Town & Country Planning Act 1990 (as amended)
Town and Country Planning (Development Management Procedure) (England) Order 2015
Application for approval of details reserved by conditions imposed under planning permission
P/125/14/PL relating to condition No. 10 (Refuse & recycling bins), condition No.14 (Visitor Parking
Spaces), condition No.15 (Surface water onto Highway), condition No. 16 (Street Lighting),
condition No. 18 (Cycle Parking), condition No. 21 (Landscaping), condition No. 22 (Screen Walls &
Fences) & condition No.26 (External Lighting), condition 31 (Dog Walking)
251 Pagham Road & Land R/O Pagham,,

Condition Number 21

Decision:

drawing title	Landscape General Arrangement (East)				
drawing no.	1896-TF-00-00-DR-L-1002				P03
scale	1:250 @ A1	date	28.09.17	drawn by	AC
				checked by	AC

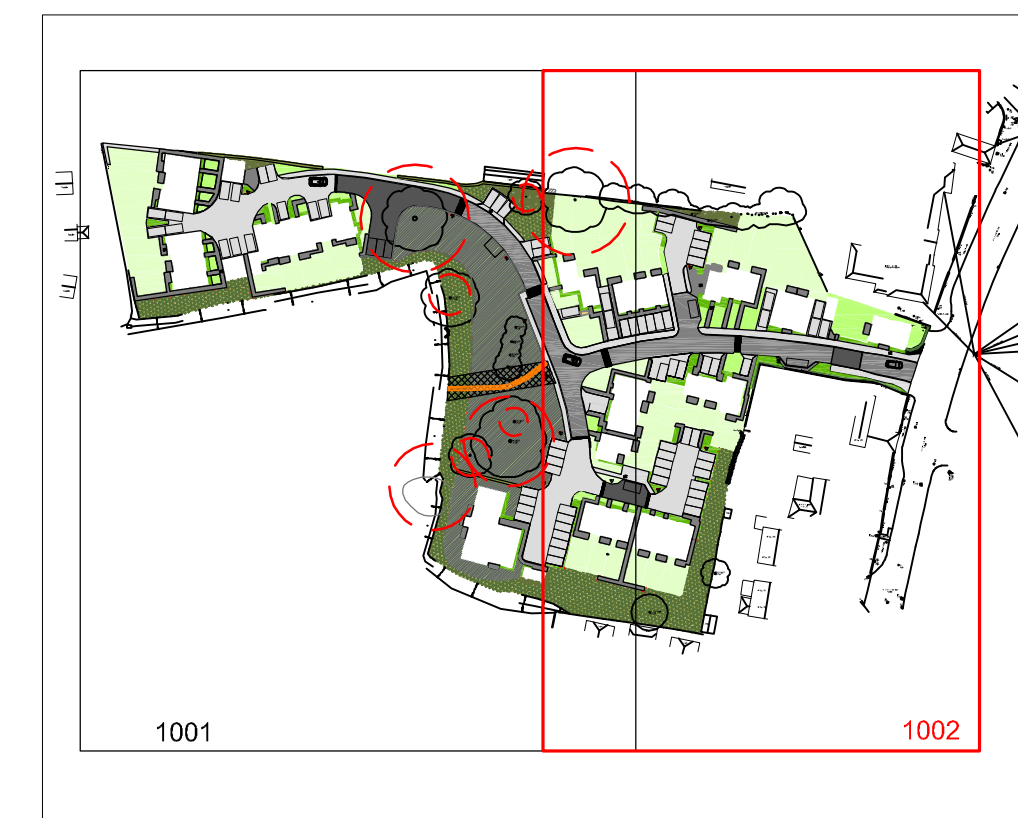
Arun District Council have decided to **APPROVE details reserved by this condition**
The submitted Landscape Scheme was revised to take account of concerns raised by a local resident and by the Councils Landscape Officer. The amended submission comprises of drawings 1896-TF-00-00-DR-L-3002 PO4; 1896-TF-00-00-DR-L-3001 PO4; 1896-TF-00-00-DR-L-1002 PO5; and 1896-TF-00-00-DR-L-1001 PO3. These are now acceptable to the Councils Landscape Officer.
